MEMORANDUM

TO: Nell Donaldson, Planner
FROM: Lauren Swett, PE
DATE: May 18, 2016
RE: AC Hotel, Final Level III Site Plan Application

Woodard & Curran has reviewed the response to comments for the Final Level III Site Plan Application for the proposed hotel located at 158 Fore Street in Portland, Maine. The project involves the construction of a new building to provide hotel rooms and retail space.

CM 4

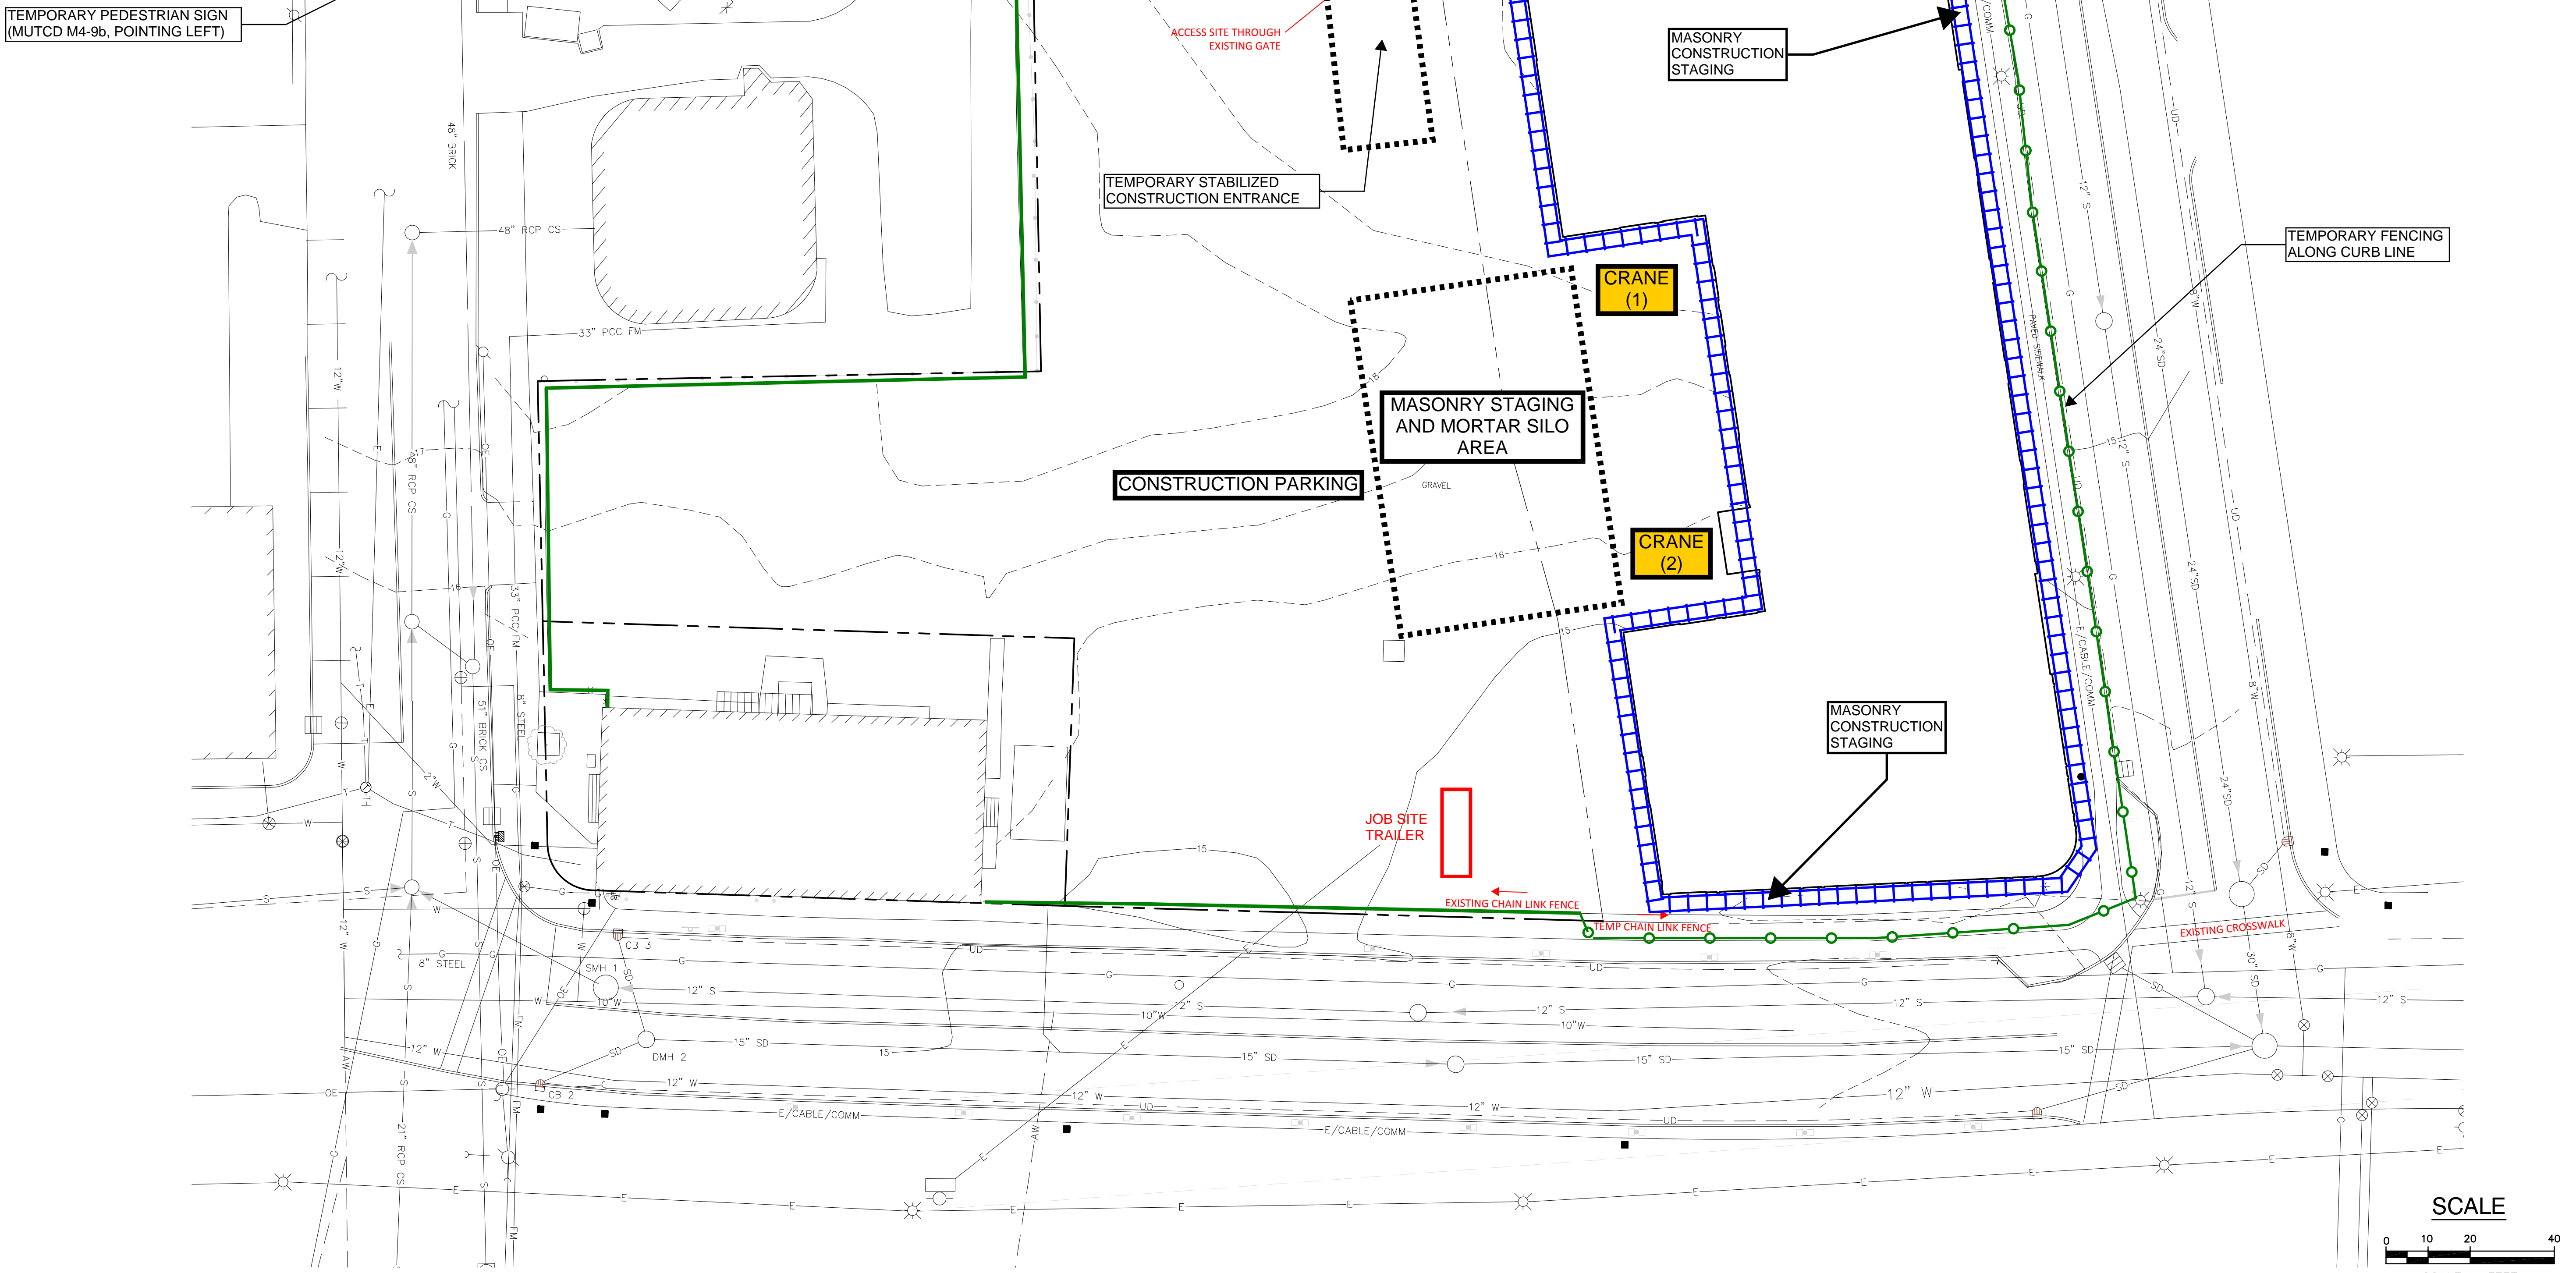
- 1) *The Applicant has noted that a construction management plan will be provided by the contractor once a contractor has been selected. If this approach is acceptable to Planning and other reviewers, the submittal of a construction management plan should be made Condition of Approval for the project.*
- 2)
